**RFI**

**RFI #: 201**  
**Date:** 10/23/2012  
**Job:** EB-02 Keller Springs Lofts  
**Phone:** 877-777-5115

**Subject:** Roof drains for the radius tower

**Drawing:** P3.5A, 3.5A  
**Cost Impact:** None

SHEET NUMBER  
**3.5A**  
 BLDG PLAN 'A'

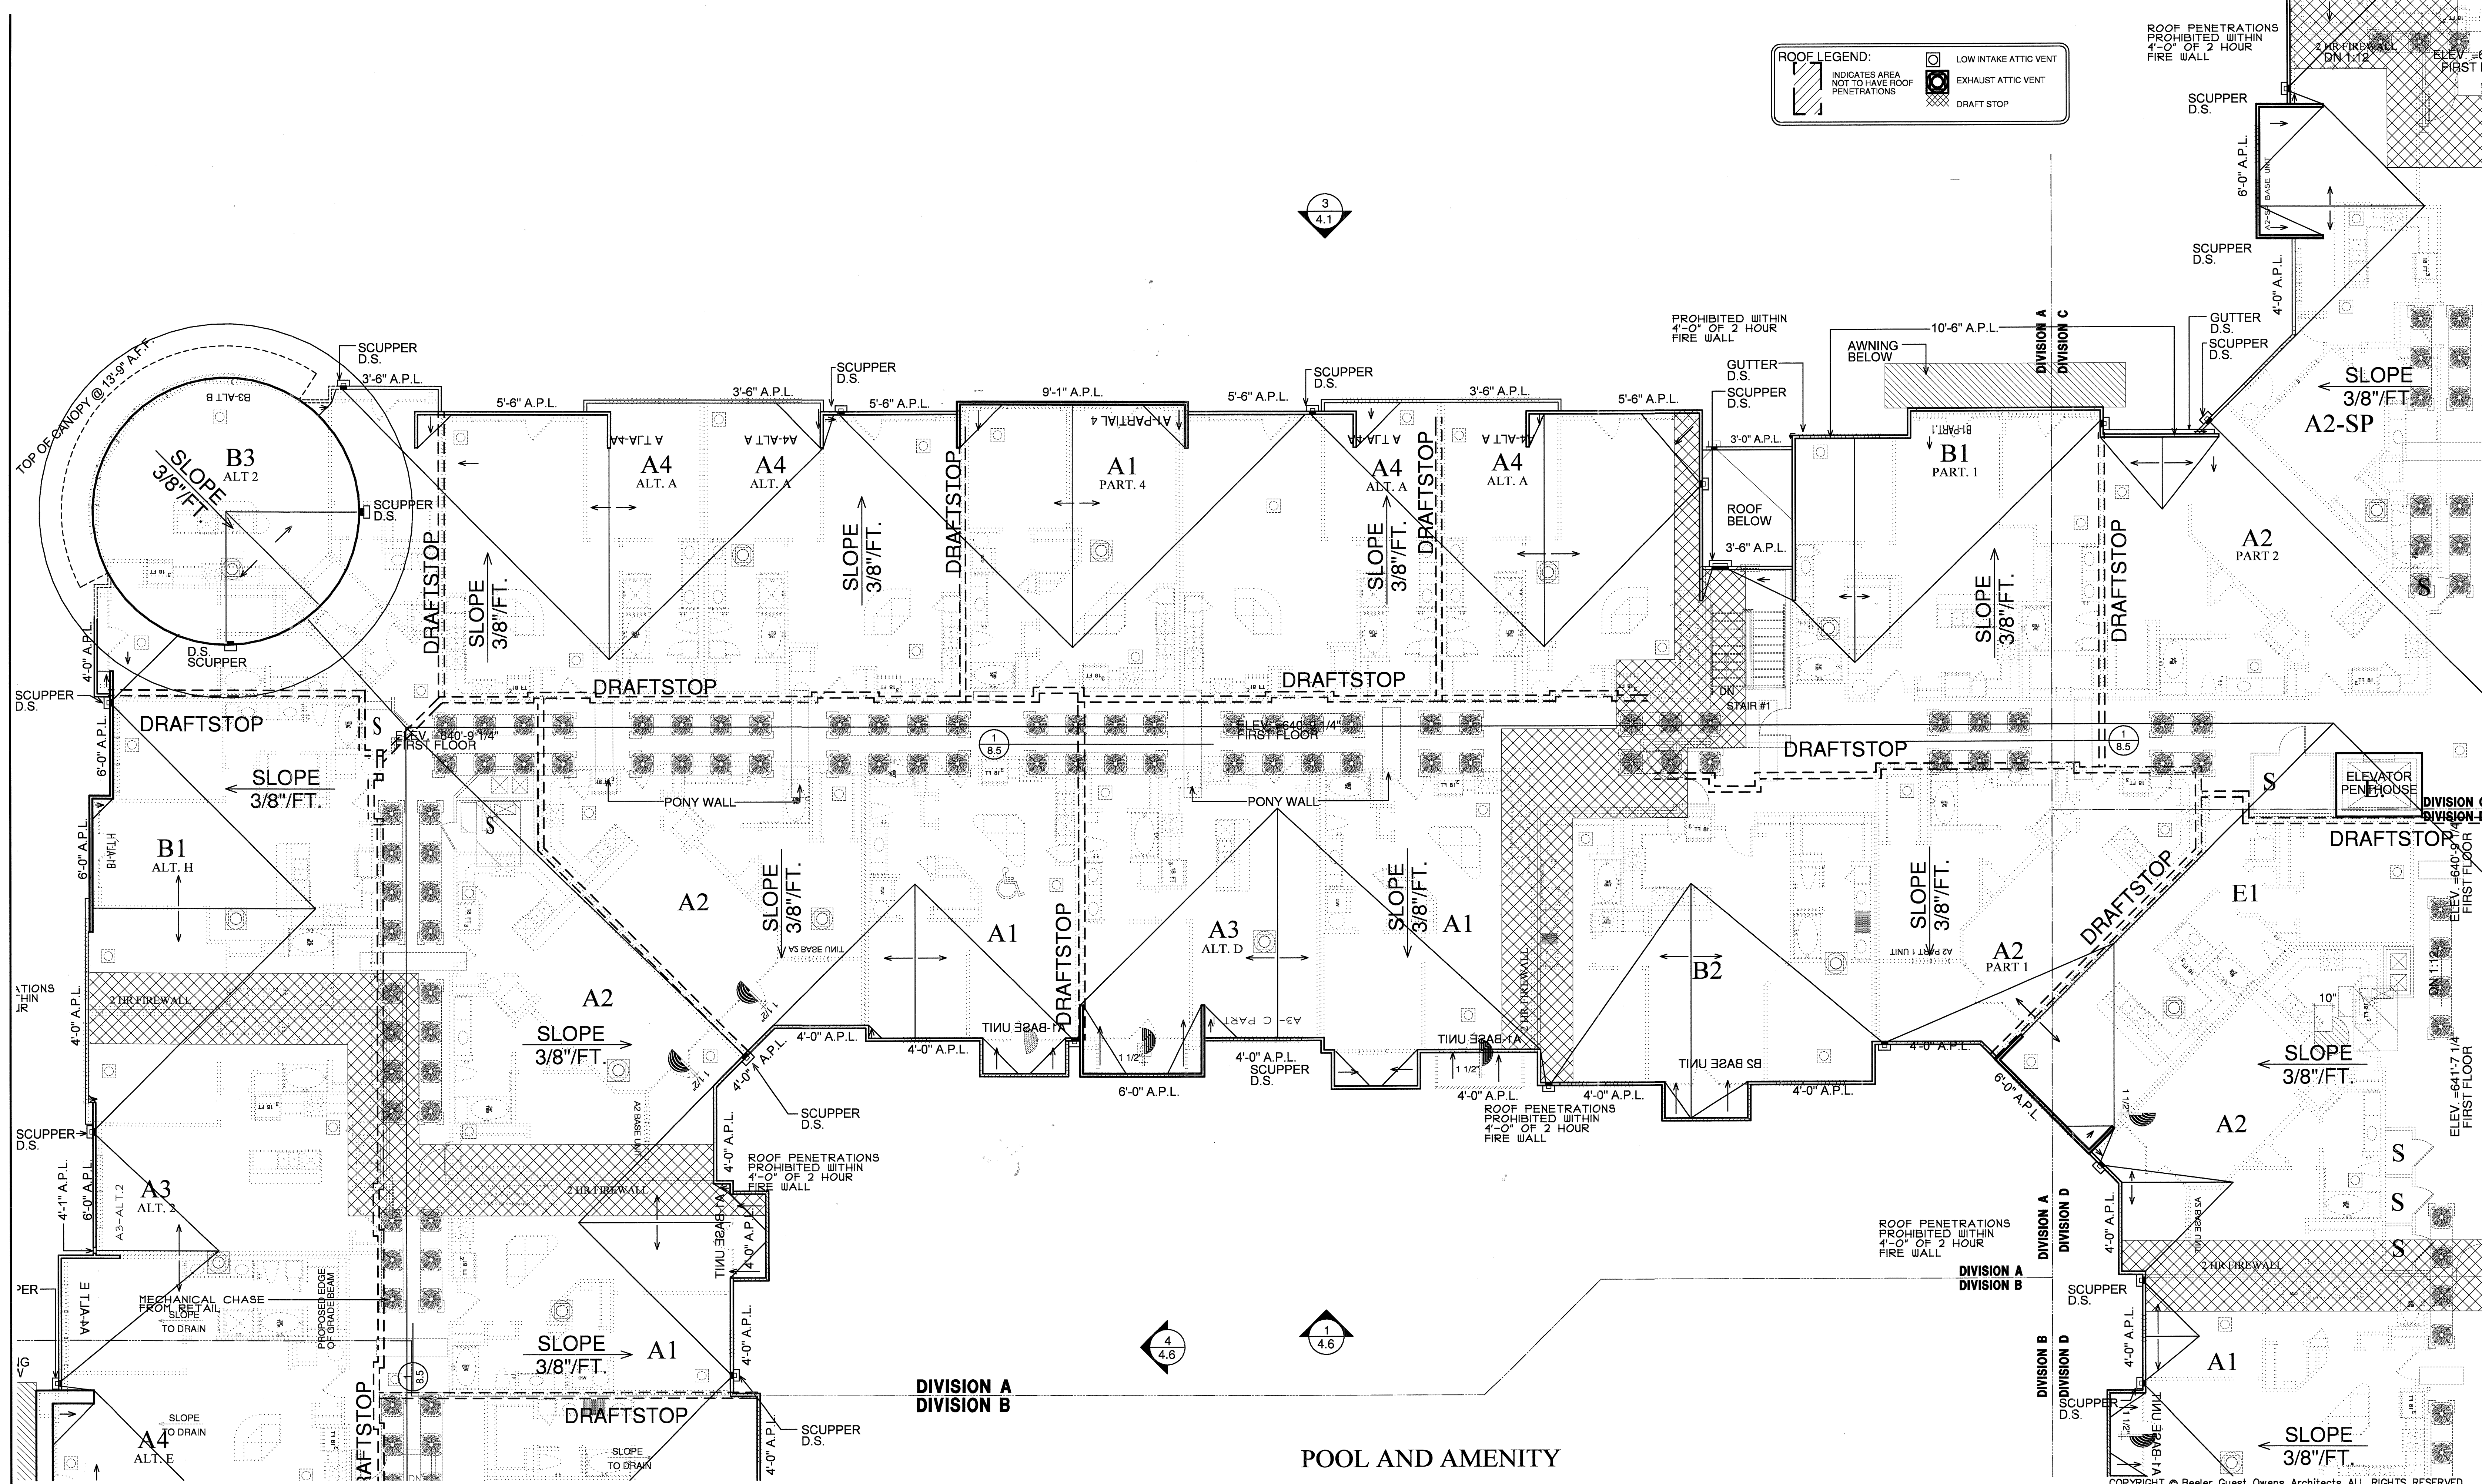
**Request:** **Date Required: 10/26/2012**  
During an on-site meeting with Walter Kilroy and Ryan Faulds of BGO Architect it was determined that we would use a drain and overflow on top of the radius located on the northwest corner of the west building. The plans showed (2) scuppers with downspouts which would not work because of the exterior angle on the radius feature. It was decided that the drain line would be located inside the radius tower until it penetrated the side of the radius tower just about the stucco receiver and drain onto the main roof. We will properly slope the roof and build crickets for the water to enter the drain. Please size and detail the drain and drain lines Jordan & Skala deems appropriate for this task.

**Response:**  
It is recommended that 4" drains and drain lines be used for the tower. Roof drain shall be Jay R. Smith #1015 or equal and overflow drain shall be Jay R. Smith #1080 or equal. provide downspout nozzle Jay R Smith #1770 or equal at discharge point.
